**2003-0261**

**498 Island Ave. PEAKS ISLAND**

RE: 498 Island Avenue, Peaks Island  
(ID# 2003-0261, CBL#090J004)

Thank you for your application for a single-family house at 498 Island Avenue. Upon review, planning department has the following comments:

BOUNDARY AND TOPOGRAPHIC SURVEY

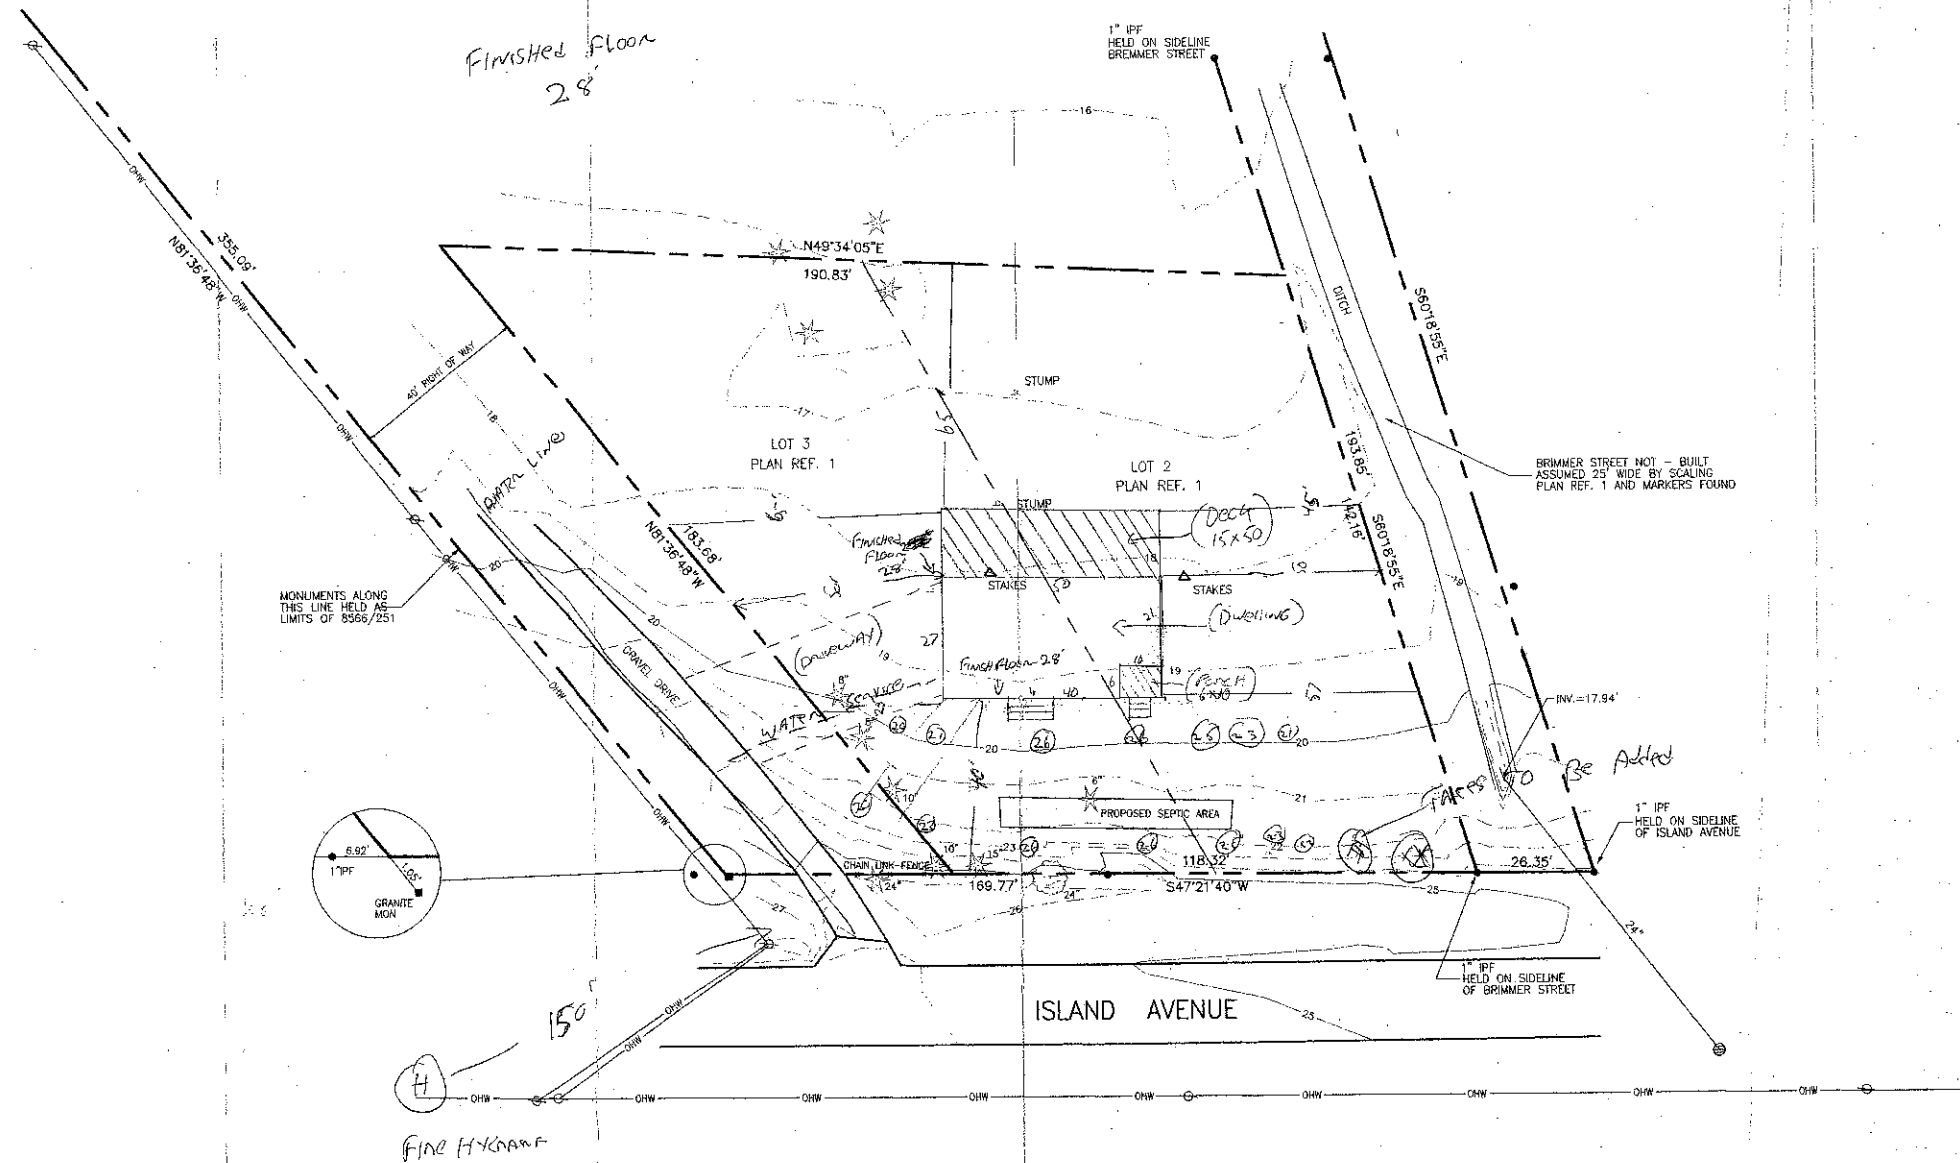
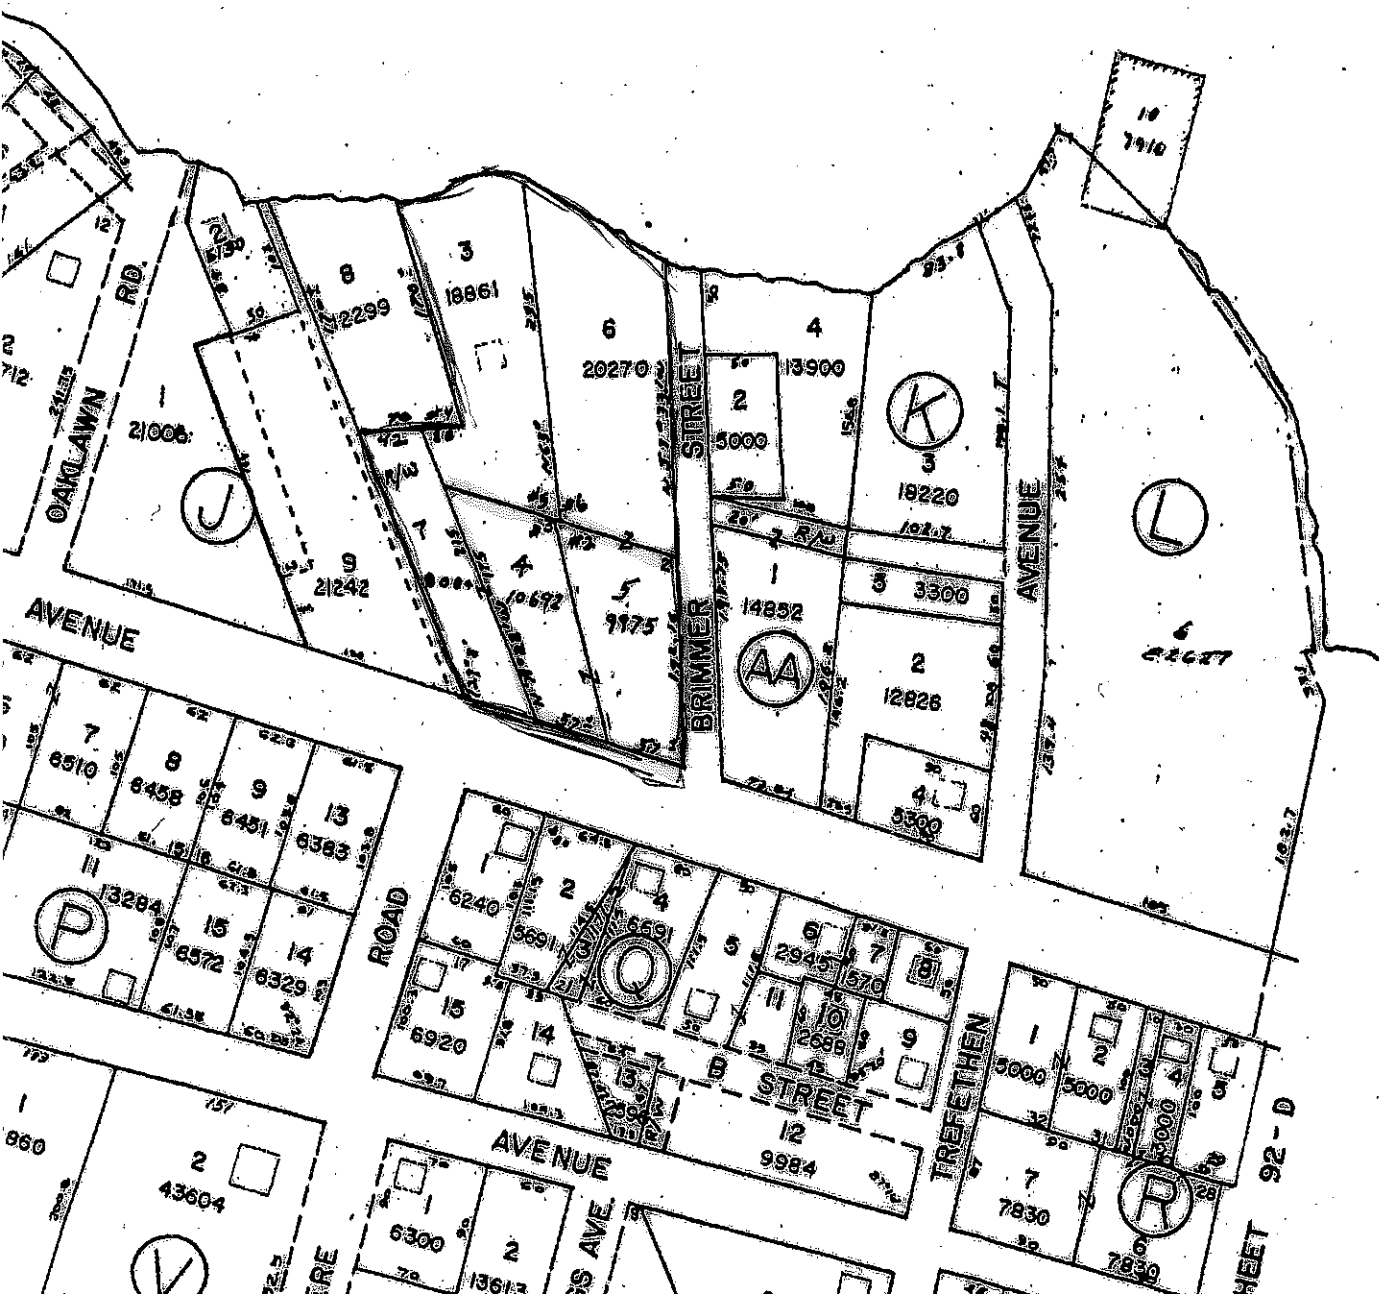
1. Please add any/all proposed changes in grading. Also, add the sill or finish floor elevation.
2. Please add 2 proposed street trees along the Island Avenue frontage of the lot, as required by ordinance for single-family development.
3. Please show the proposed water service/well that will service the new building.
4. Please note the distance of the nearest fire hydrant on the site plan.
